GRAHAM STORAGE - LATIGO BUS CENTER, FILING 1
PEYTON, CO
FINAL LANDSCAPE PLAN

PROJ. NO.:
 DATE: 11.30.20
 SCALE: See Sheet
 DRAWN: JRO
 CHKD BY: NAM
 SHEET L10

Landscape Plan drawings_v1.pdf Markup Summary

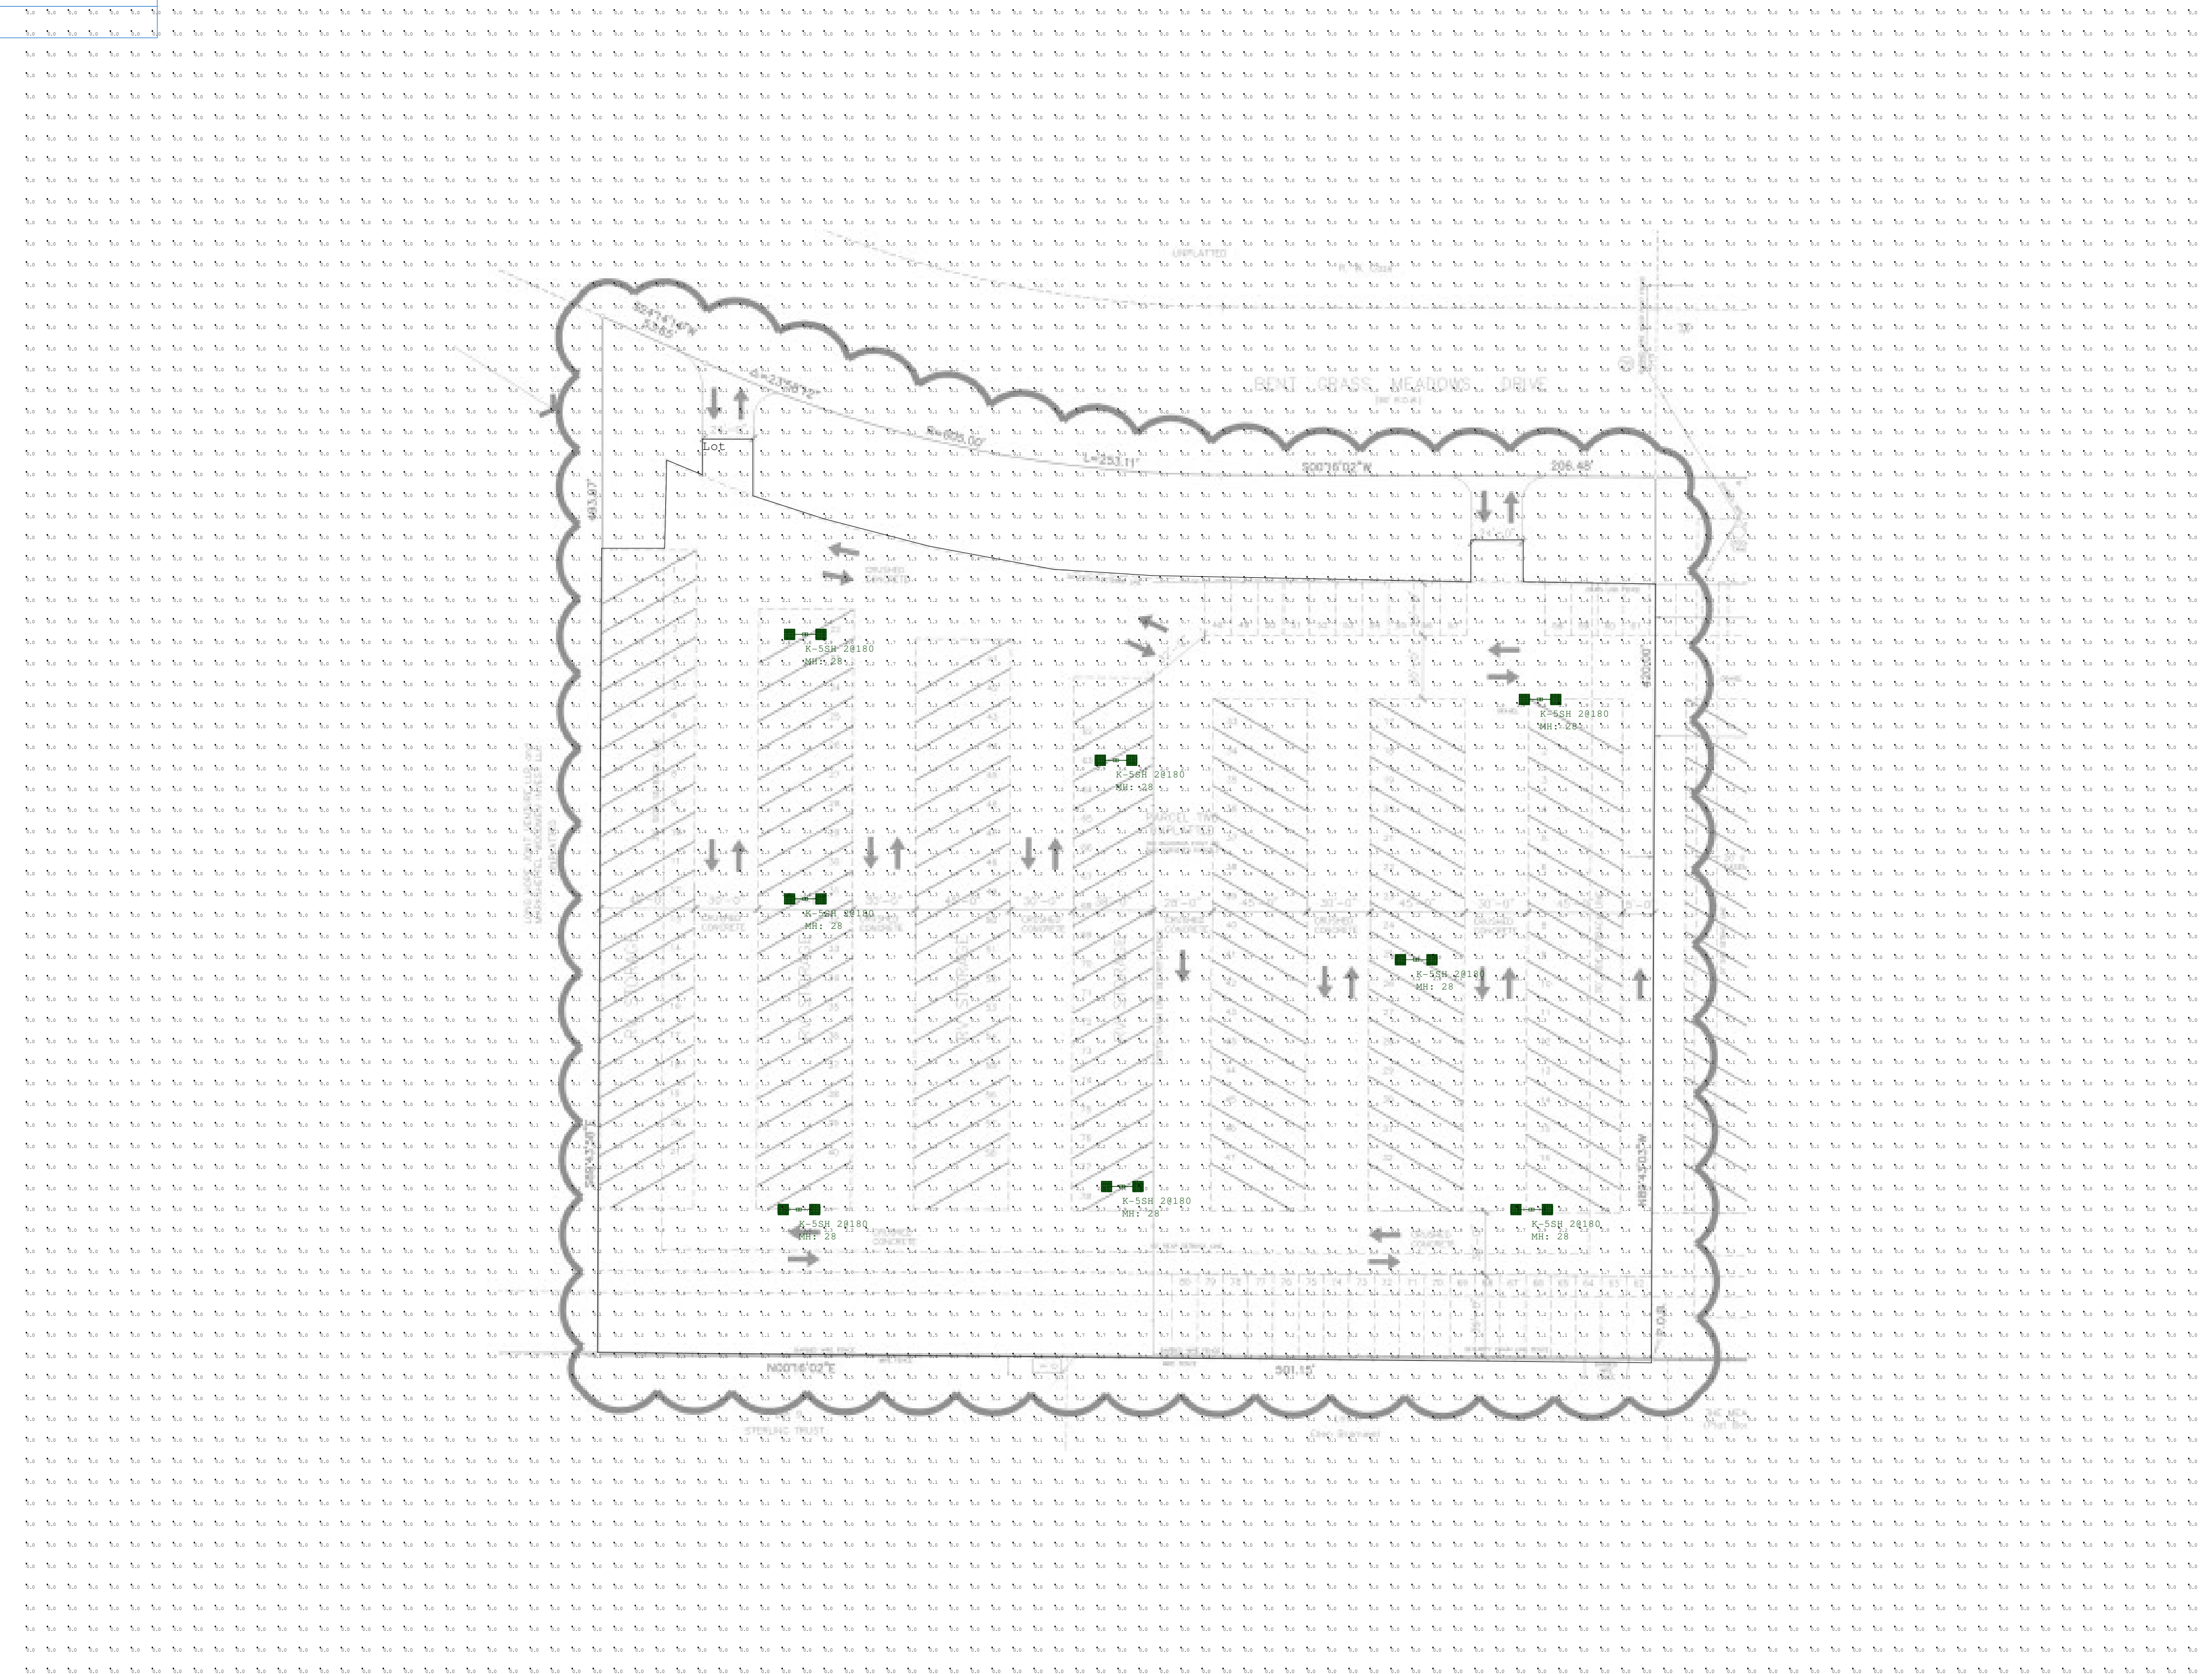
Please change file number to PPR2232
